RE: Harnett County Land Use Existing Tank Application # 17-5-41568

The Harnett County Department of Public Health, Environmental Health Division evaluated the above referenced property at the site designated on the plat/site plan that accompanied your existing tank application. According to your application, you are requesting that a previously built 12 x 20 shed be permitted. The evaluation was done in accordance with the laws and rules governing wastewater systems in North Carolina General Statute 18A.1950 including related statutes and Title 15A, Subchapter 18A, of the North Carolina Administrative Code, Rule.1950 and related rules.

Based on the criteria set out in Title 15A, Subchapter 18A, of the North Carolina Administrative Code, Rules .1950, the evaluation indicated that the site is **UNSUITABLE** for the addition requested. Therefore, your request for an existing tank is **DENIED**. The site is denied based on the following statute:

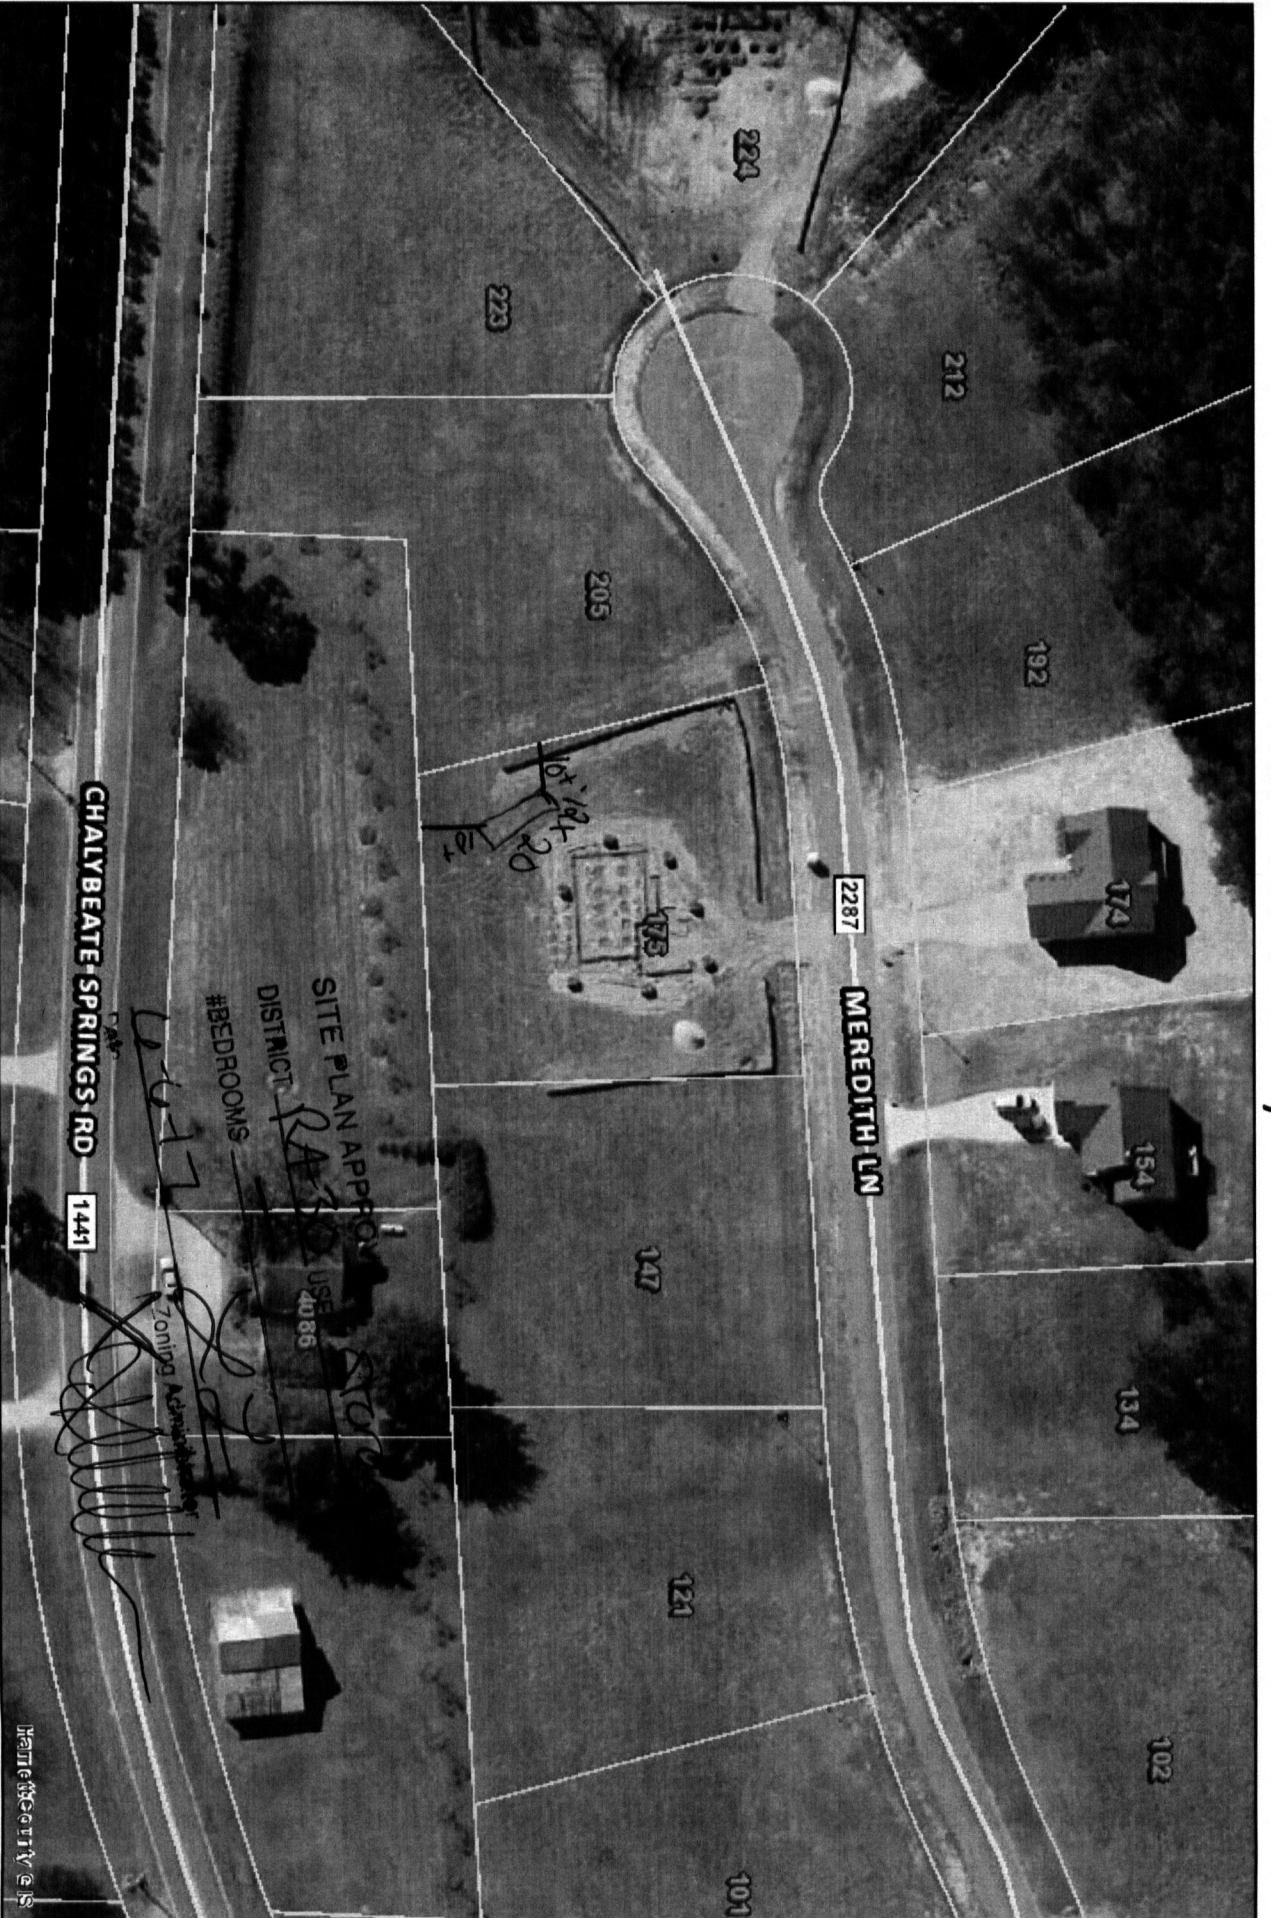
- 15A NCAC 18A.1950a {16} - Any swimming pool must be 15' from any part of septic system.
- 15A NCAC 18.1945{b} - Each lot shall have original septic system plus repair area.
- 15A NCAC 18A.1950 {10} - Any building to be 5' from septic tank and/or from drain line.
- 15A NCAC 18A.1950{c} - Nitrification fields and repair areas shall not be located under paved areas or areas subject to vehicular traffic.

Your building has been placed on top of the drain lines and it will have to be moved. Call me to discuss further in detail. If you should have any questions or concerns, I can be contacted Monday through Friday from 8am – 9am at 910-893-7547.
